MARCH 30, 2021

RE: NEW SINGLE FAMILY RESIDENCE  
179 SUMMERLIN DRIVE  
SANFORD, NORTH CAROLINA

THE ABOVE REFERENCED RESIDENCE IS BEING CONSTRUCTED UNDER YOUR BUILDING PERMIT NUMBER SFD2012-0022.

FOUNDATION PLAN
Scale: 1/4" = 1'0"

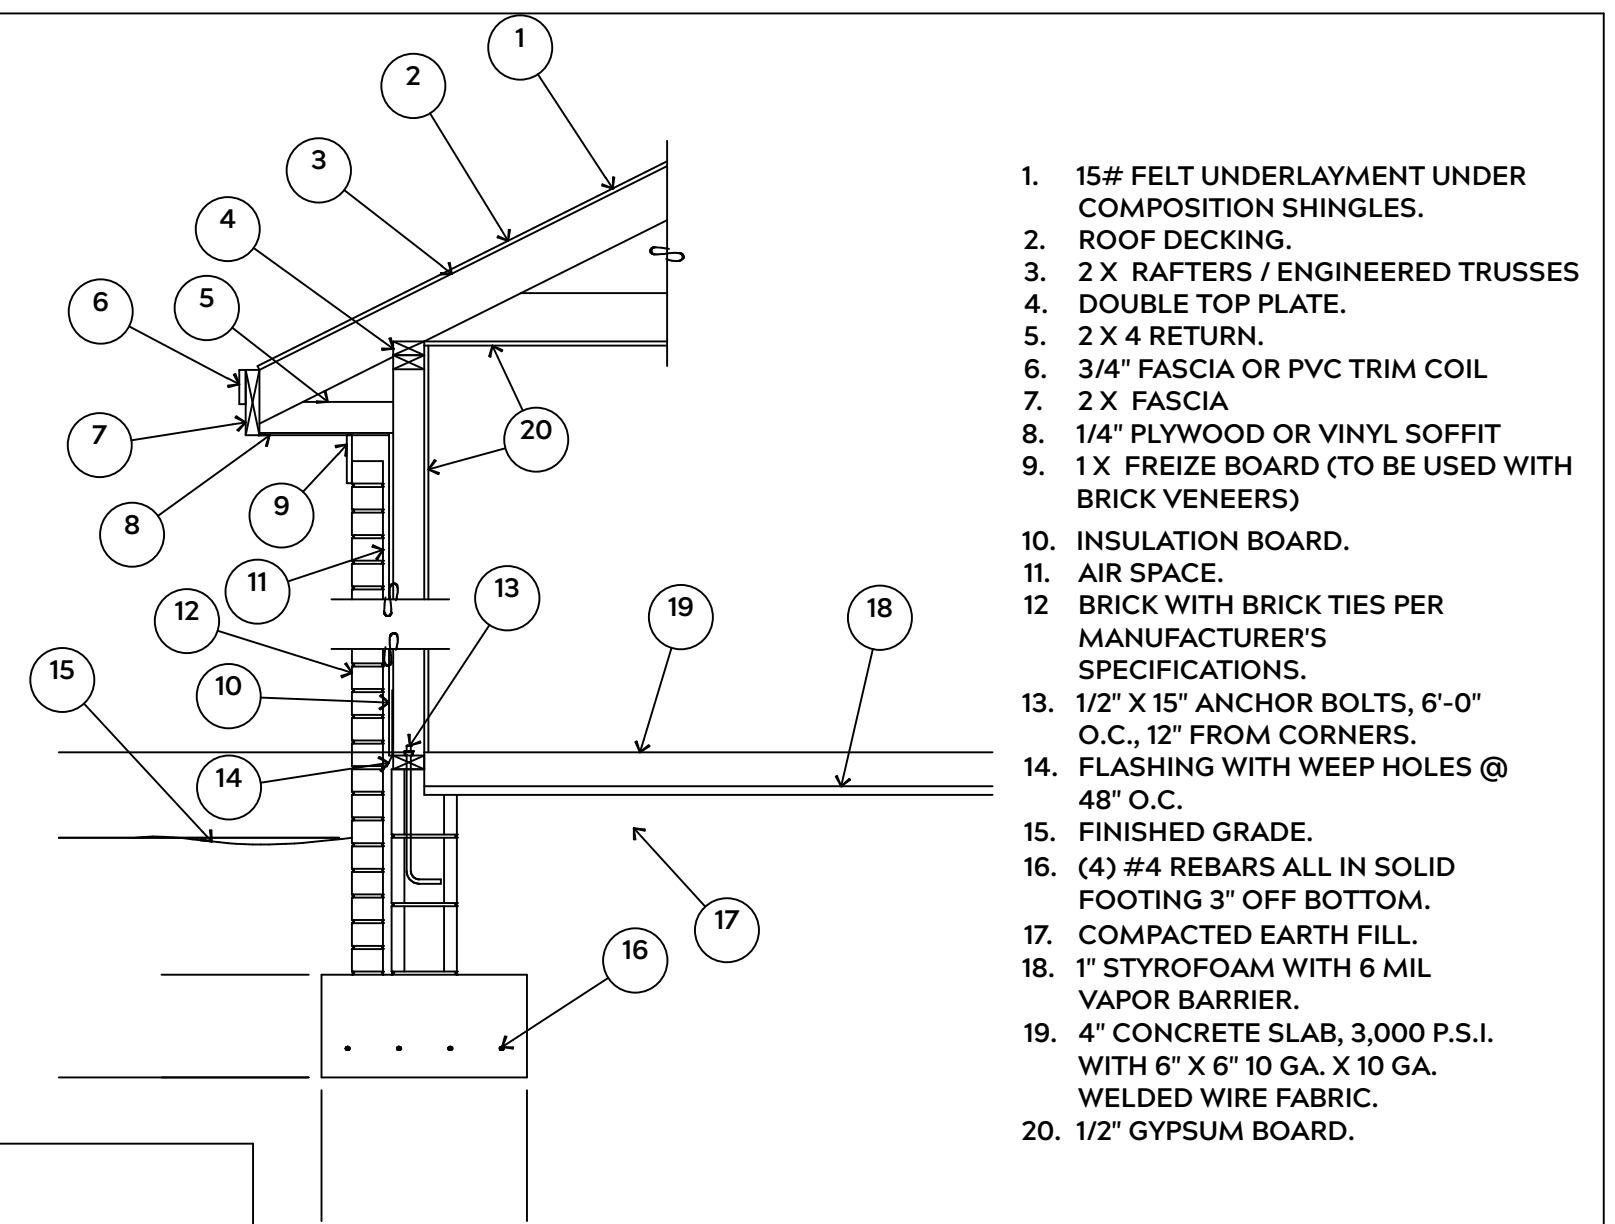
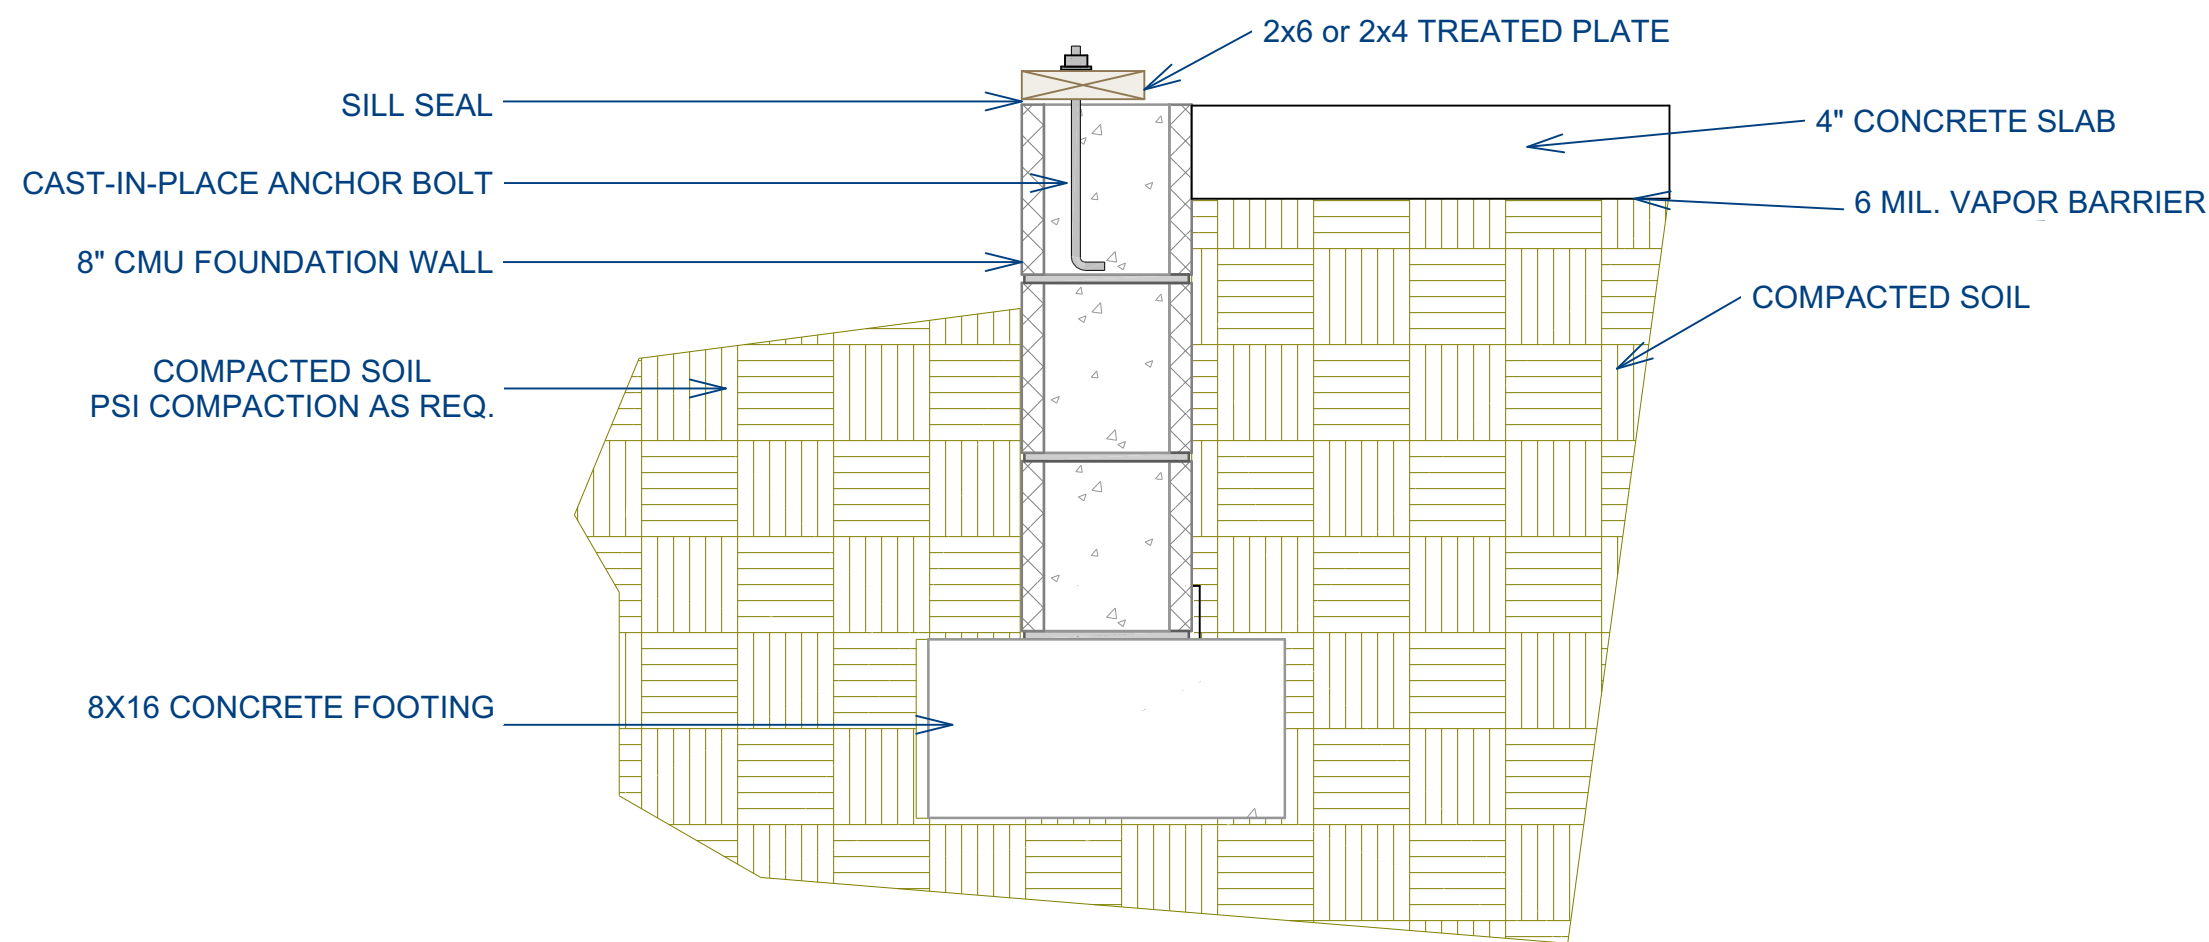
BASED UPON MY PREVIOUS SITE VISIT AND INSPECTIONS OF THE CONCRETE FOOTINGS AND FOUNDATION WALLS, I OBSERVED THE FOUNDATION WALL BETWEEN THE GARAGE AND THE LIVING AREA OF THE RESIDENCE WAS NOT CONSTRUCTED AS THE APPROVED DRAWINGS FOR THIS RESIDENCE INDICATED. A PORTION OF THIS WALL WAS CONSTRUCTED WITH 12 INCH MASONRY UNITS IN LIEU OF 8" UNITS. THIS ALTERED THE OVERHANG PROJECTION OF THE CONCRETE FOOTING ON EACH SIDE OF THE WALL.

THE LIVING AREA SIDE OF THE WALL HAD ONLY MARGINAL PROJECTION OF THE CONCRETE FOOTING. I ADVISED THE CONTRACTOR TO PLACE ADDITIONAL CONCRETE ALONG THE LIVING AREA SIDE OF THE WALL. THE ADDITIONAL CONCRETE NEEDED WOULD BE A MINIMUM OF 4 INCHES WIDE, 14 INCHES DEEP AND EXTEND UNDER THE EXISTING CONCRETE FOOTING A MINIMUM OF 4 INCHES.

THE CONTRACTOR HAS NOW PLACED THE REQUIRED CONCRETE ADJACENT TO THE EXISTING CONCRETE FOOTING AS DESCRIBED ABOVE.

I HEREBY CERTIFY THAT THIS PORTION OF CONCRETE FOOTING AND FOUNDATION WALL IS SAFE AND IS STRUCTURALL ADEQUATE TO SUPPORT ALL LOADS REQUIRED BY THE NORTH CAROLINA STATE RESIDENTIAL BUILDING CODE, 2018 EDITION.
